Sea Link

Document 7.4.9: Draft Statement of Common Ground Between National Grid Electricity Transmission and the Harwich Haven Authority.

Planning Inspectorate Reference: EN020026

Version: [BC](#)  
~~November 2025~~  
[March 2026](#)

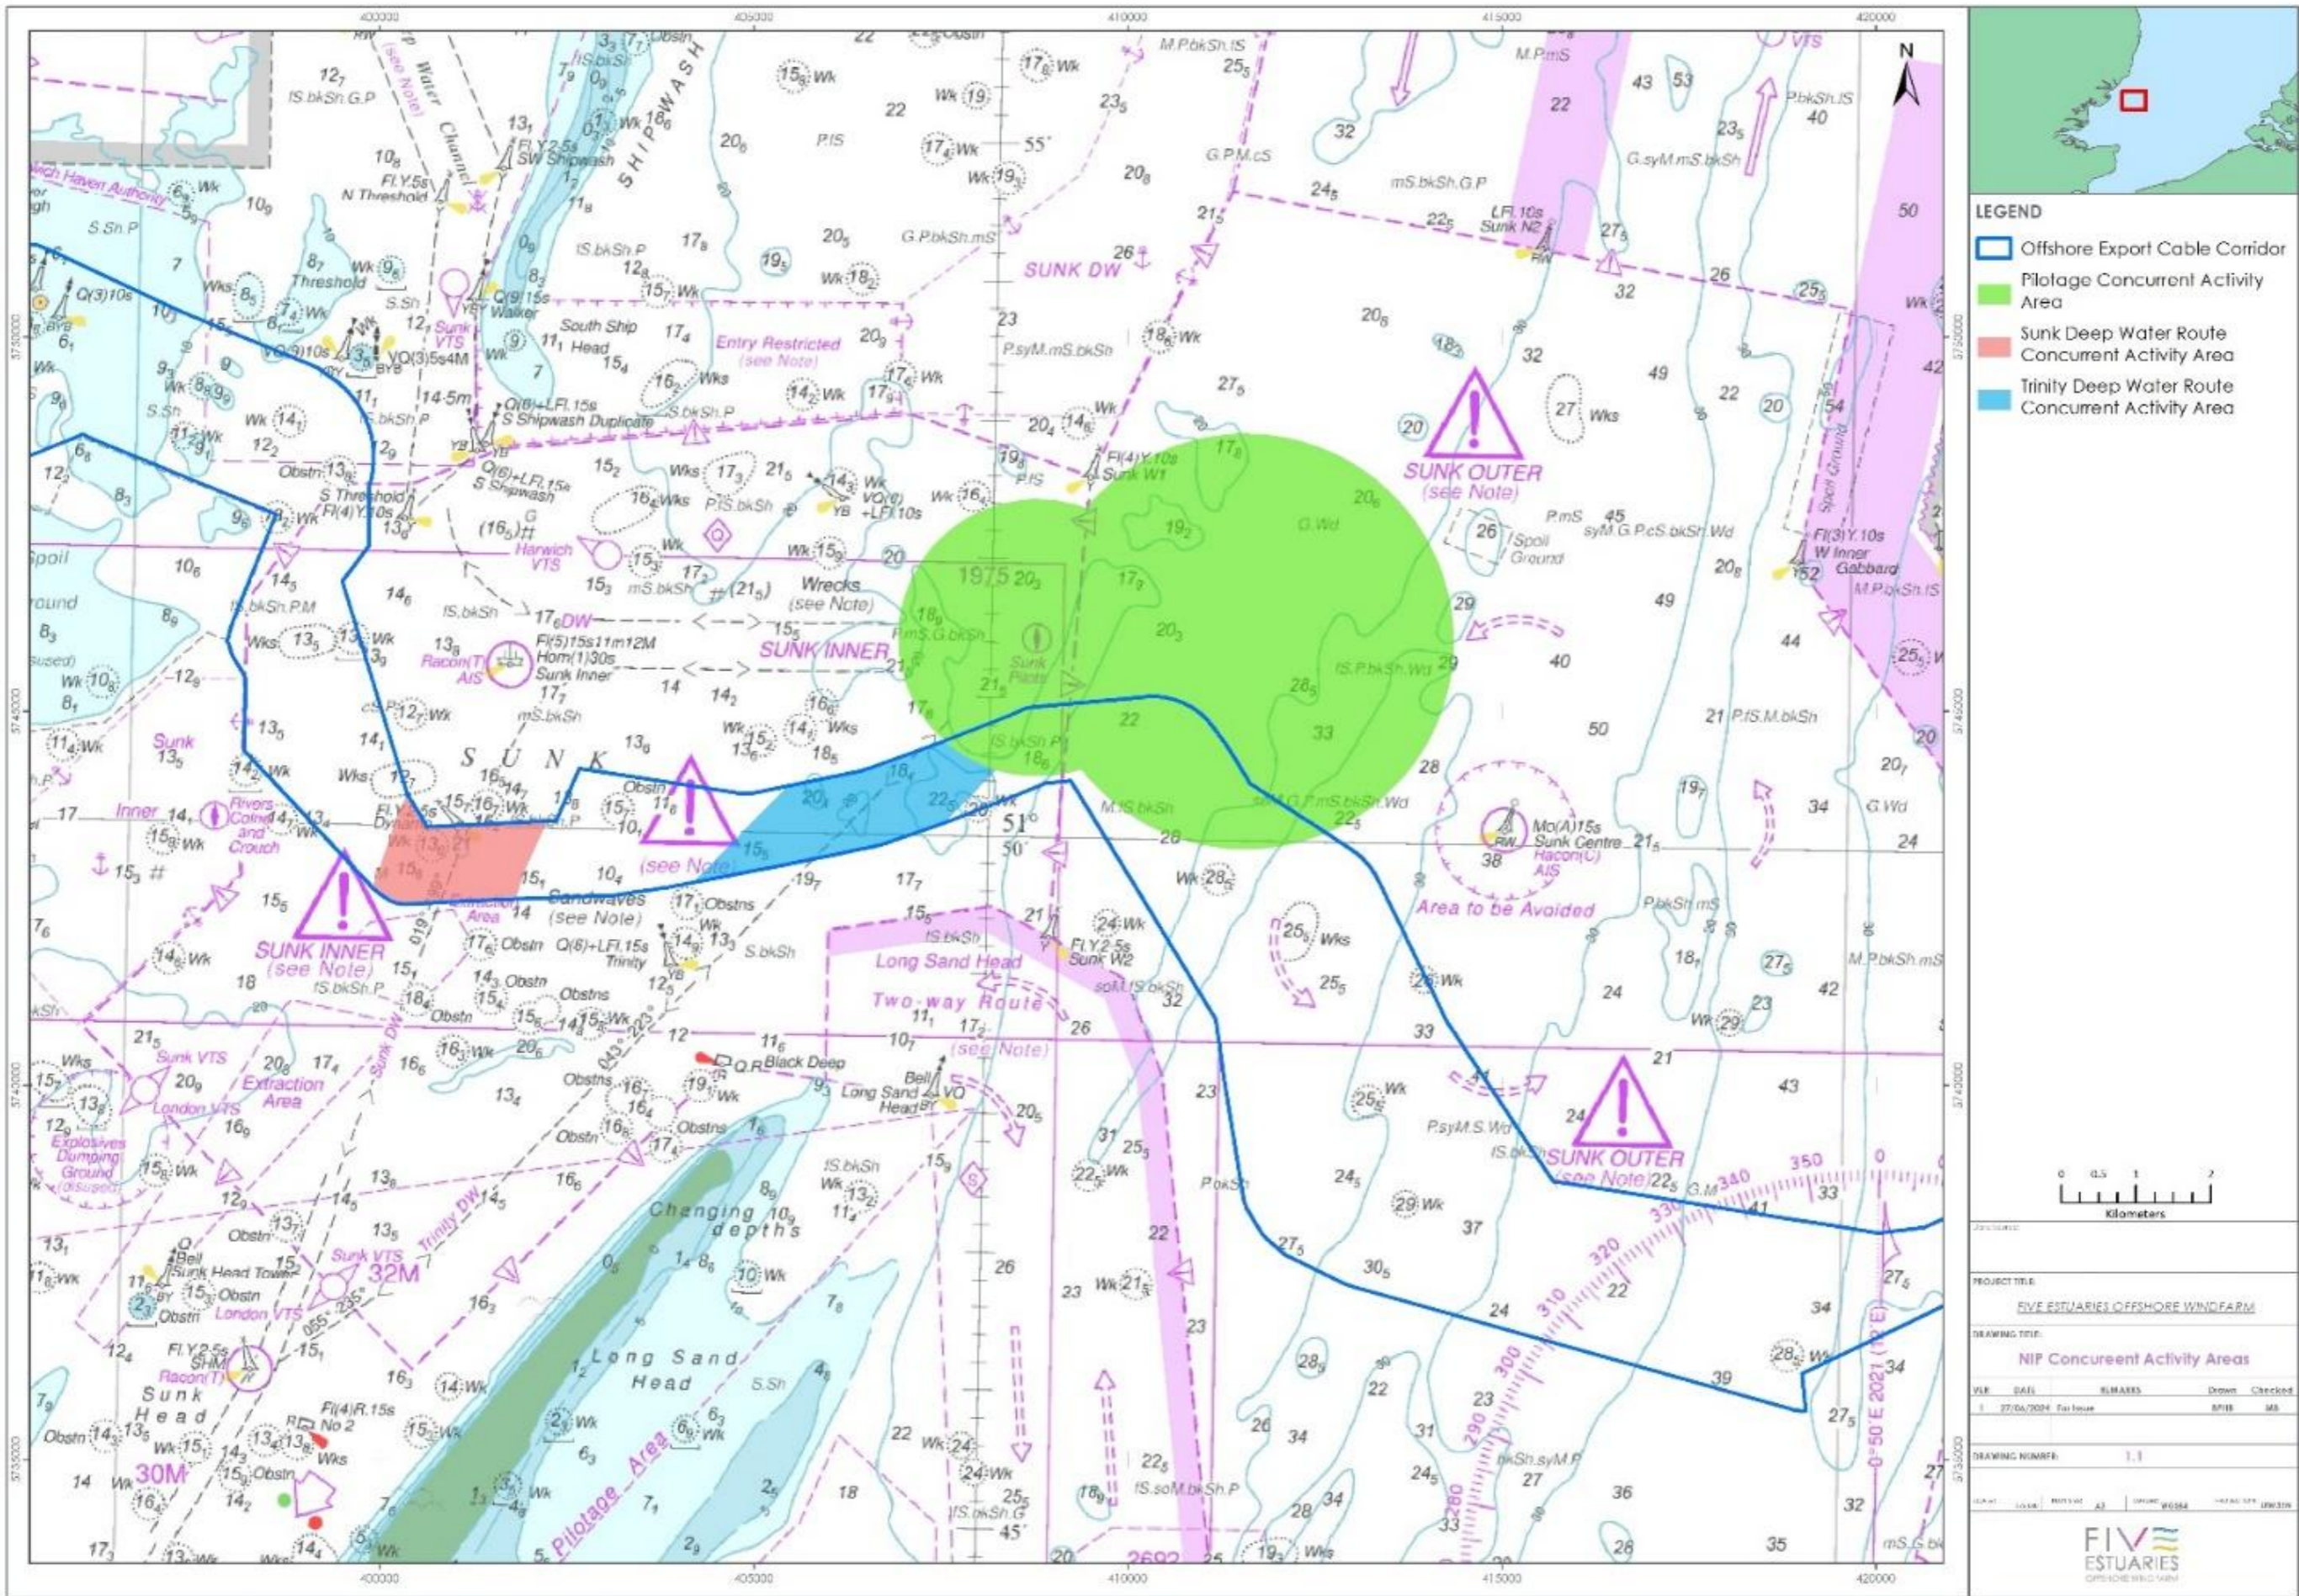
3.2.2	<b>Application Document 6.2.4.7 (C) Part 4 Marine Chapter 7 Shipping and Navigation [APP-080REP4-035].</b>	Scheduling	<p>The Consultee requests that no works conducted as part of the Proposed Project should run concurrently with works already planned by Five Estuaries and North Falls project operators in the area, as it is their opinion that this would cause an unacceptable level of navigation risk.</p> <p>The Consultee requests that no Restricted Ability to Manoeuvre (RAM) works conducted by the Proposed Project should run concurrently with RAM works already planned by the Five Estuaries and North Falls project developers in the Sunk area (or other future projects). It is the Consultee's opinion that this would cause an unacceptable level of navigational risk. Therefore, the Consultee insists that the Sea Link project liaise with other planned project teams and the Consultee to avoid this situation. This requirement for no RAM concurrent works, operations or activity must be written into the DCO.</p> <p>Concurrent RAM construction activity / SIMOPS in the Sunk area (highlighted green on the below chart section) has not been assessed the developer's navigation risk assessment. We do not consider the overt risk from more than one RAM operation in the defined area to be ALARP.</p> <p>If necessary, a first come first serve policy for RAM works will have to be instigated, although combined planning by the developers should avoid the need for this.</p>	<p>The Applicant agrees with the Consultee that simultaneous operations (SIMOPS) between different projects undertaking RAM works would be undesirable. The Applicant will consult with the other projects on timescales and keep all of its marine stakeholders informed on any potential interactions. <a href="#">These mitigations are captured within Application Document 6.2.4.7 (C) Part 4 Marine Chapter 7 Shipping and Navigation [REP4-035].</a></p> <p><del>These mitigations are captured within Application Document 6.2.4.7 Part 4 Marine Chapter 7 Shipping and Navigation [APP-080].</del></p> <p><del>The Applicant is producing</del> <a href="#">The Applicant confirms that the Navigational Installation Plan (NIP) is the most appropriate place to secure concurrent RAM operations. This also aligns with the approach taken in the Five Estuaries and North Falls DCO applications.</a></p> <p><a href="#">The Applicant has produced</a> a communication protocol in the form of a Navigation Installation Plan (NIP) to address this need for communication of construction details and enable collaboration with other offshore developments. The NIP establishes the plan for communication throughout key project phases, in particular the construction phase. This is noted in <b>Application Document 6.2.4.7 (C) Part 4 Marine Chapter 7 Shipping and Navigation [APP-080]. REP4-035.</b></p> <p>The NIP also establishes the 'Concurrent Activity Area' within which such RAM SIMOPS restrictions would apply. The Applicant submitted a draft Outline NIP to PINS on 1 September 2025, as part of the Applicant's response to the ExA's s89(3) letter dated 5 August 2025.</p> <p><del>The Applicant will undertake further discussion with other offshore projects to understand what commitment can be</del></p>	Under discussion

Ref	Relevant Application Document	Summary of Description of Matter	HHA Current Position	The Applicant's Current Position	Status
				<p><del>made on the matter of simultaneous RAM operations. The Applicant is seeking to agree to this requested commitment and discussions are ongoing with the relevant stakeholders.</del></p> <p>Further to the above, the Applicant confirms that an update to <b><u>Application Document 9.12 (B) Outline Navigation and Installation Plan [REP4-076]</u></b> was submitted at Deadline 4 which is secured within the Deemed Marine Licence (DML) under Condition 4-(g).</p> <p>Condition 4-(g) of the DML requires the Navigation and Installation Plan to be submitted to and approved by the MMO before works can commence. This Plan needs to be in accordance with the outline Plan (which already features the commitment). Once submitted to and approved by the MMO it forms part of the licensed activities which are enforced by the existing and comprehensive regulatory regime under the Marine and Coastal Access Act 2009.</p> <p>This document secures the HHAs request that no Restricted Ability to Manoeuvre (RAM) works conducted by the Proposed Project should run concurrently with RAM works already planned by the Five Estuaries and North Falls project developers in the area defined within Plate 3.1 of <b><u>Application Document 9.12 (B) Outline Navigation and Installation Plan [REP4-076]</u></b> and outlined as the green area in the figure below.</p>
